From: Sarah Burrow <Sarah.Burrow@arun.gov.uk>
Sent: 28 July 2021 14:10
To: Planning.Responses <Planning.Responses@arun.gov.uk>
Cc: Maria Tomalova <Maria.Tomalova@arun.gov.uk>
Subject: RE: Planning Consultation on: P/95/21/PL

Application No: P/95/21/PL
Registered: 21st June 2021
Site Address: Bowley Farm Bowley Lane South Mundham Chichester PO21 1NB
Grid Reference: 489226 98589
Description of Works: Retention of 4 mobile homes for countryside workers together with drainage and service connection provision in connection with permission P/72/09 as varied by P/22/017/PL (resubmission following P/86/20/PL). This site is in CIL Zone 5 (Zero Rated) as other development.

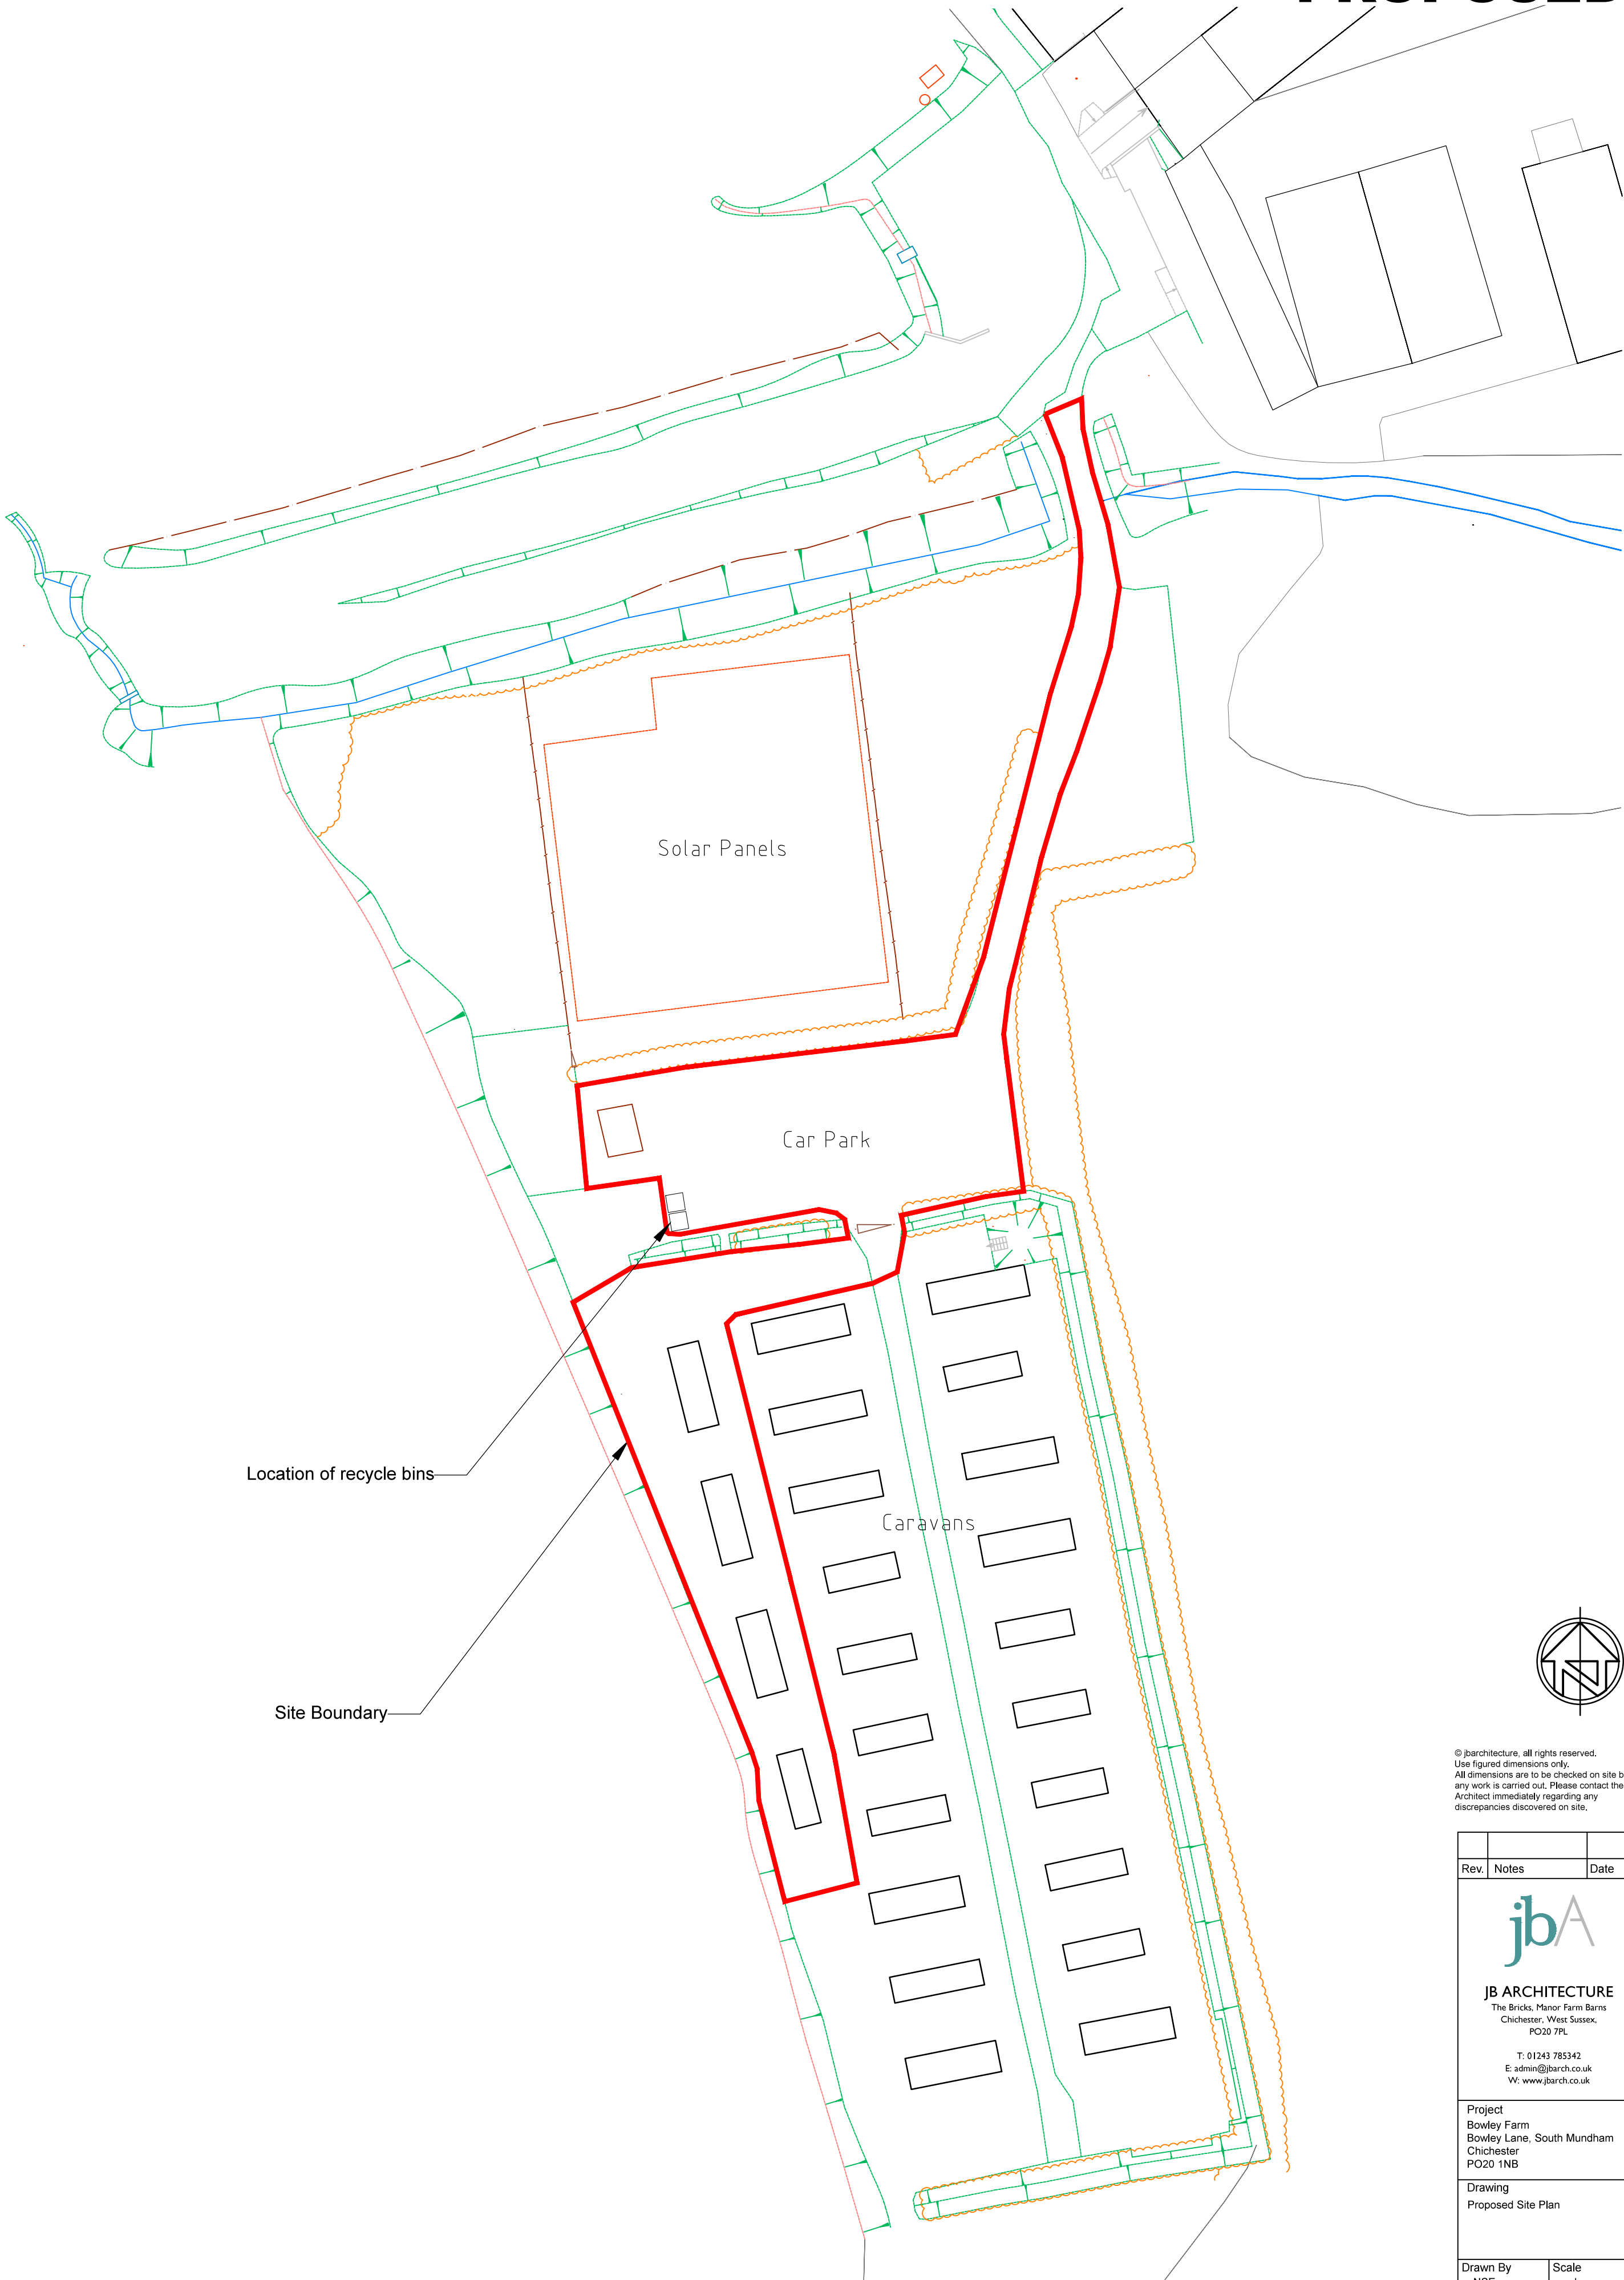
I note that the proposed caravans are located within the 3m buffer zone approved under P/96/11/DOC. This buffer zone was requested and agreed to by the Environment Agency, please consult them and our Ecology Officer for their opinion about the proposed encroachment on this zone.

I would add that the 3m buffer also provides the necessary area to undertake maintenance to the watercourse. If any formal connection is to be made to the watercourses in the vicinity of the site then Ordinary Watercourse Land Drainage Consent will be required.
